**Planning Department
Transportation Development Services**

October 15, 2014

**Re: Health Care for the Homeless, 1220 First Street NW
Traffic Circulation Layout**
Architect's Stamp dated 9-26-14 (J14-D172)

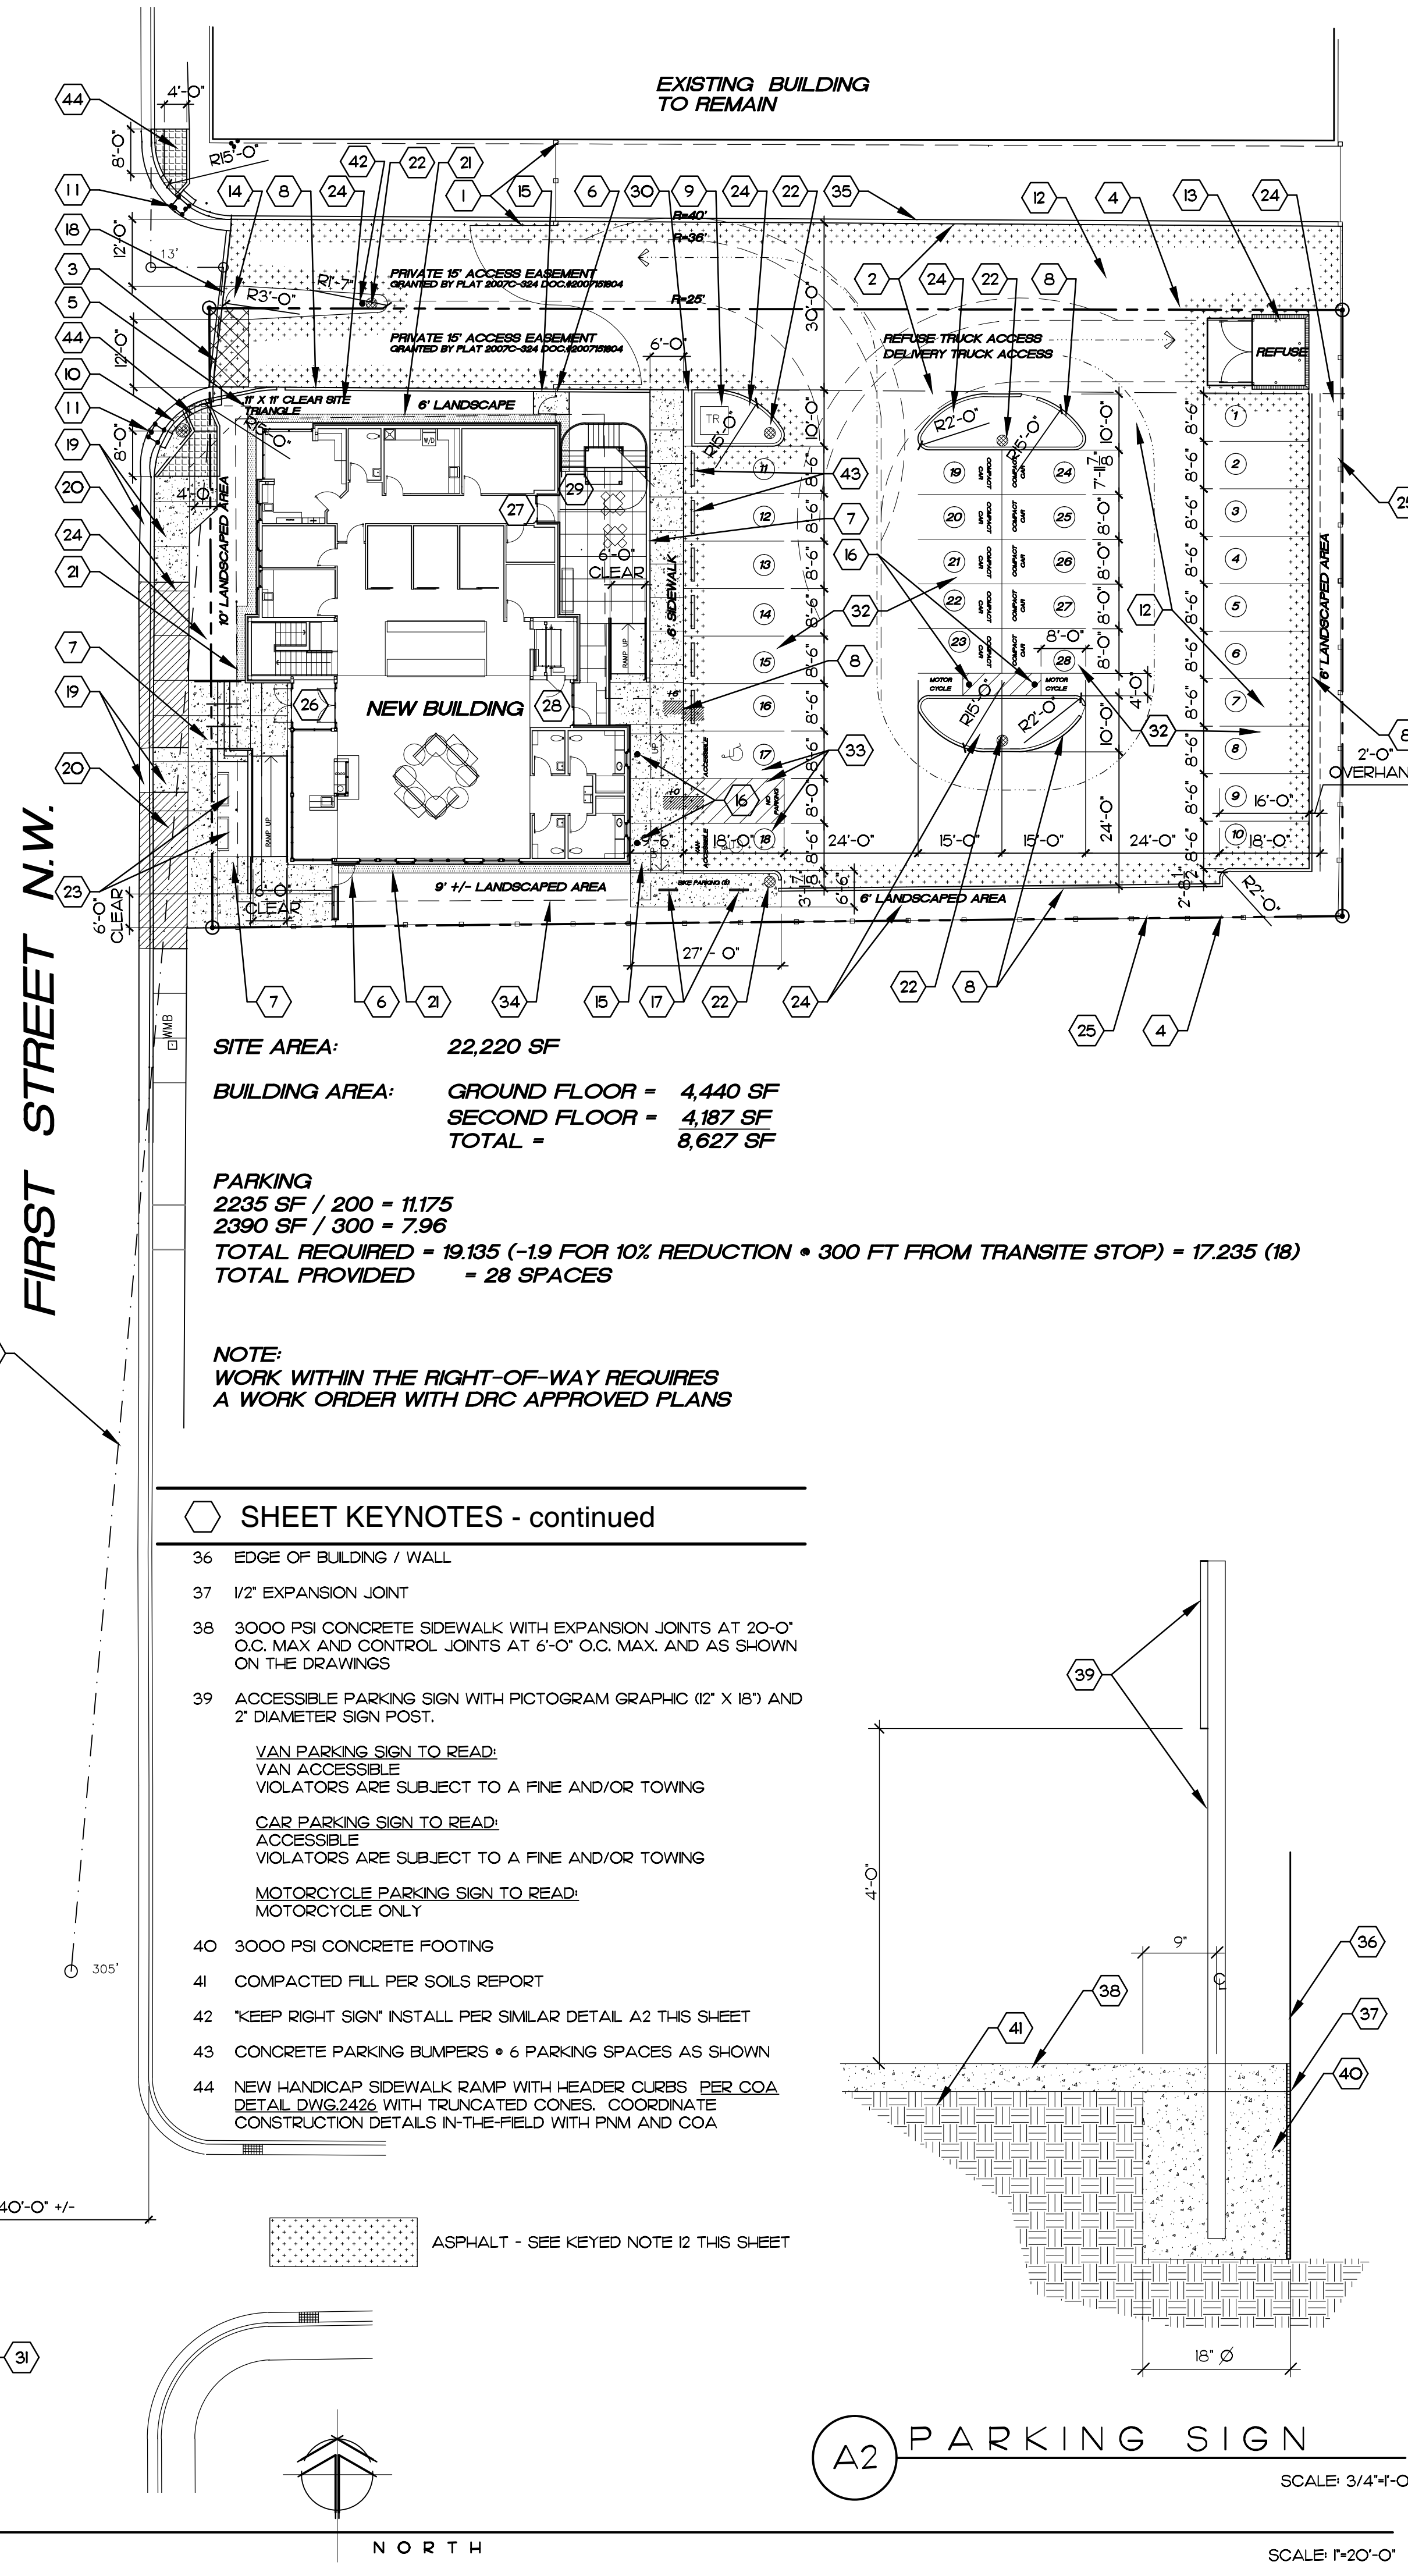
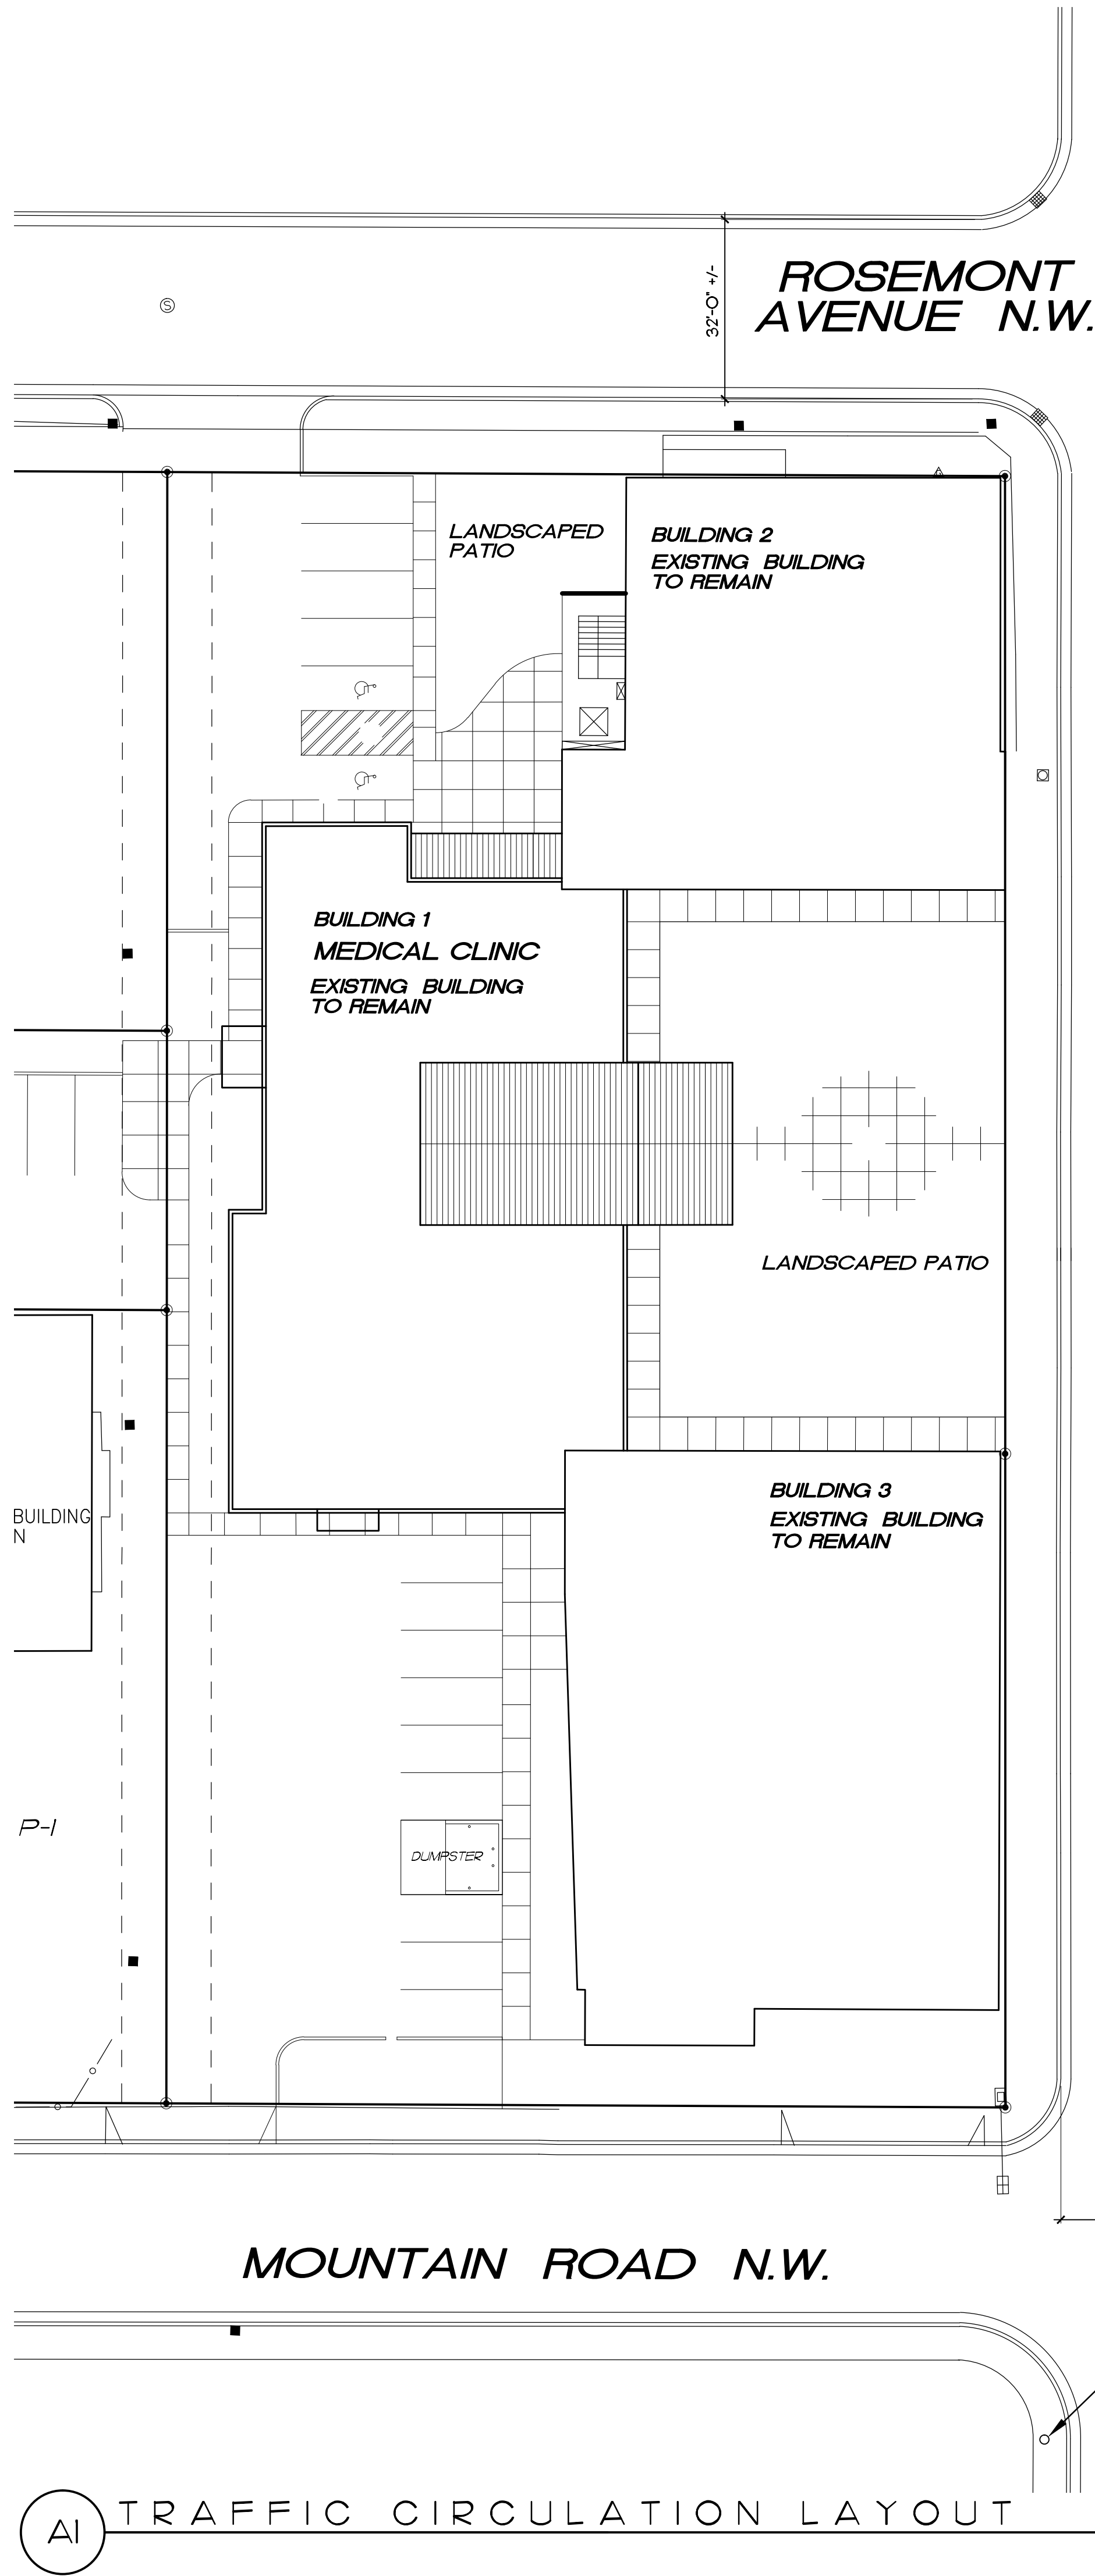
1. The total required number of parking spaces is listed as 18, but a total number of 28 is provided. Please clarify.
2. Identify the existing street widths for Rosemont Avenue and First Street. Label the 15-foot access easements as "Private 15-foot Access Easements".

3. The handicap accessible spaces must be a minimum of 8.5 feet in width. One is shown as only 8.0 feet wide.
4. The parking spaces on the east side of the lot are shown as 16 feet wide, and they need to be a minimum of 18 feet wide.

5. Provide signage detail as called out by Keyed Note 16 on the plan. The ADA van accessible sign must have the required language per 66-7-352.4C NMSA 1978 **"Violators Are Subject to a Fine and/or Towing."**

6. The words **"NO PARKING"** in the ADA access aisle shall be at least one foot high and at least two inches wide (66-1-4.1.B NMSA 1978). Designate this on the drawing.

7. List radii for all curb radii on entrance to access easements from First Street. Also, include curb radii information for the median. Wheelchair ramps must be provided for wheelchair access across the 30-foot access easement along with truncated domes. Show lane widths from the median curb to the outer curb.

8. The new PNM Pole called out on Keyed Note 10 needs to be a minimum of 18 inches behind the face of curb.

9. Provide a "Keep Right" sign on the median for traffic entering the access easement from First Street. Paint the median curb yellow.
10. A 6 foot-wide ADA accessible pedestrian pathway is required from the public sidewalk on First Street to the building entrances. Please widen the ramp up to the primary building front entrance to 6 feet wide.

11. A 6 foot-wide ADA accessible pedestrian pathway is required from the HC parking stall access aisles to the building entrances. Please widen the ramp from the parking lot up to the back door access to 6 feet wide.

12. Provide a 6-inch or 8-inch high concrete barrier curb between the parking lot and the 8-foot sidewalk on the east side of the new building.
13. The design delivery vehicle route needs to be shown.

14. It is not apparent what type of pavement surface is being proposed. A hard driving surface will be required as part of this proposed project for parking area and drive aisles. Show and label thickness of asphalt if providing an asphalt parking lot.

15. Please add the following note to the clear sight triangle: "Landscaping and signage will not interfere with clear sight requirements. Therefore, signs, walls, trees, and shrubbery between 3 and 8 feet tall (as measured from the gutter pan) will not be acceptable in this area."
